WEST SUSSEX COUNTY COUNCIL CONSULTATION

TO:	Arun District Council FAO: Anita Gardner
FROM:	WSCC - Highways Authority
DATE:	24 May 2021
LOCATION:	Wicks Farm Ford Lane Ford BN18 0DF
SUBJECT:	F/7/21/PL Building a new 1.28 Ha high-tech glasshouse, reservoir and parking area adjacent to the existing 6 Ha glasshouse, reservoir and nursery area.
DATE OF SITE VISIT:	n/a
RECOMMENDATION:	More information
S106 CONTRIBUTION TOTAL:	n/a

Drawing No
6648-CHOK-GH-GF-DR-P-0010-003

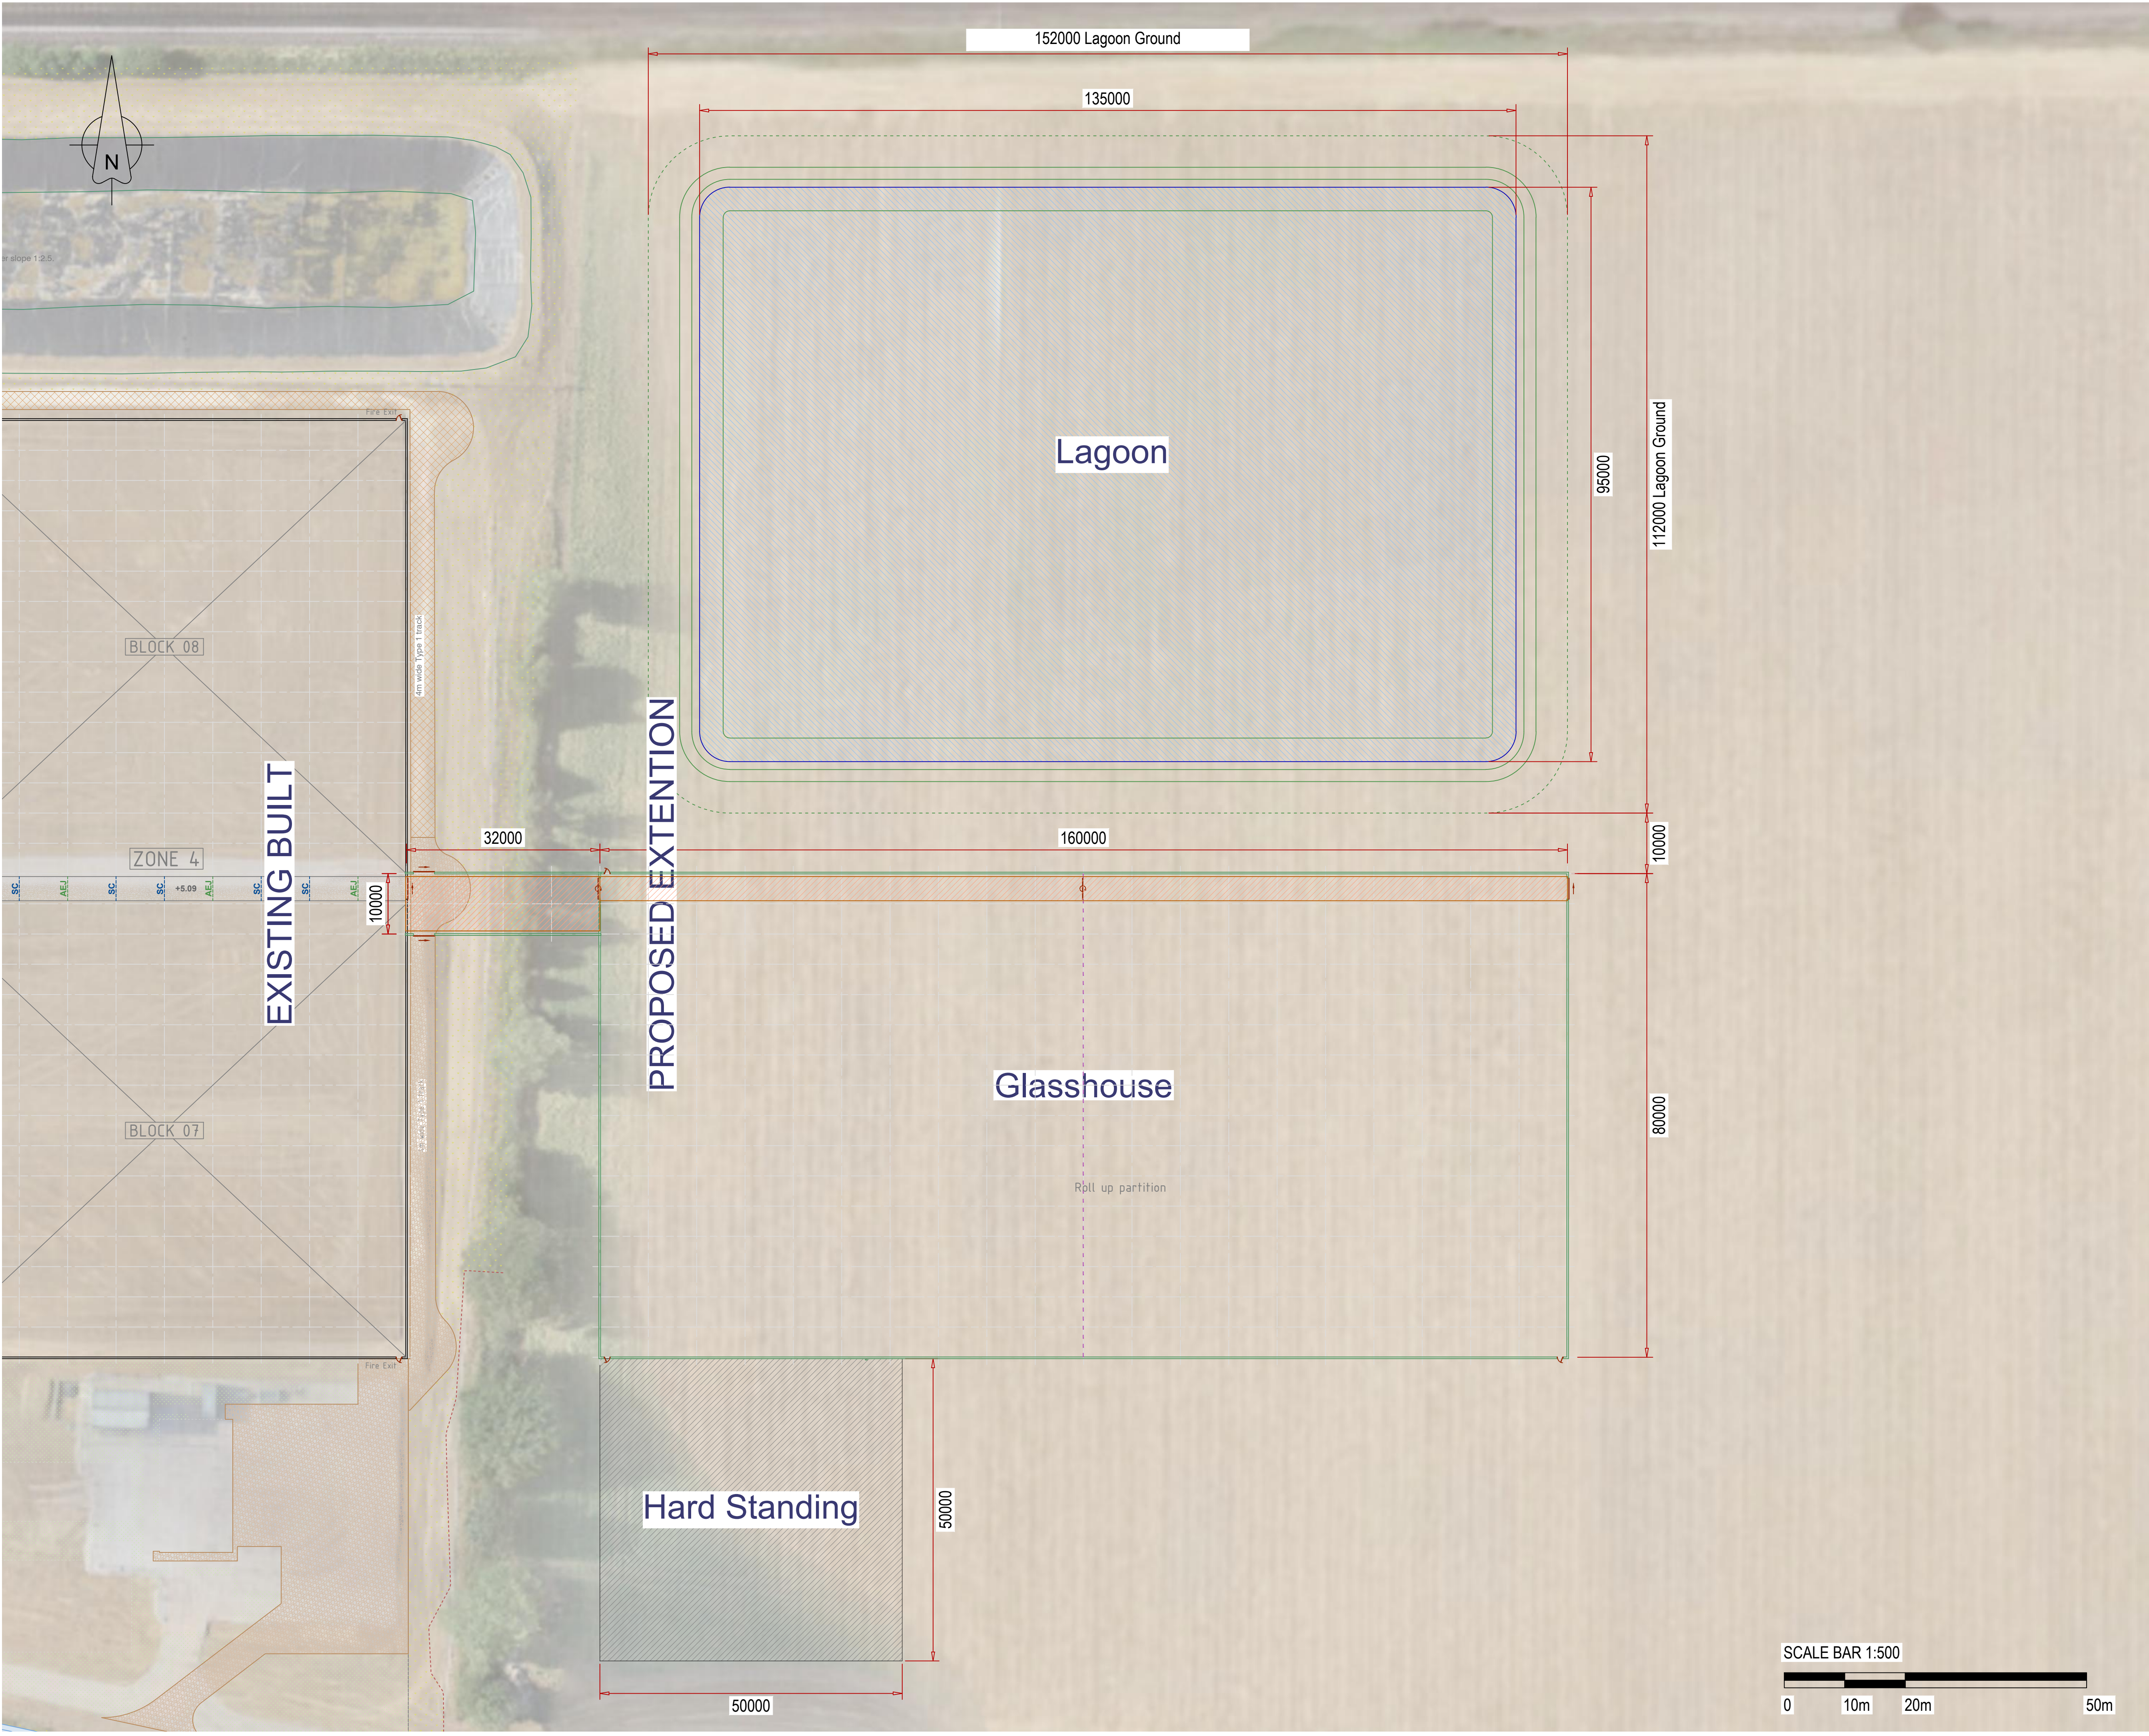
The provided plans do not clearly demonstrate the proposed access for the site, Drawing 03 indicates that the access approved under F/23/19/PL will be utilised, however Drawing 6648-CHOK-GH-GF-DR-P-0010-002 demonstrates that the access approved under F/30/18/PL will be utilised. The LHA request clarification as to which access will be utilised.

The Transport Statement indicates that no additional parking will be required, as all new staff trips will be by minibus although the LHA note that a proposed parking area is included within this application. It is also unclear how this parking area will be accessed within the site, as it appears to be isolated. The LHA request clarification regarding the parking area - what types of vehicles will this parking area be utilised for and how will this area of hard-standing be accessed?
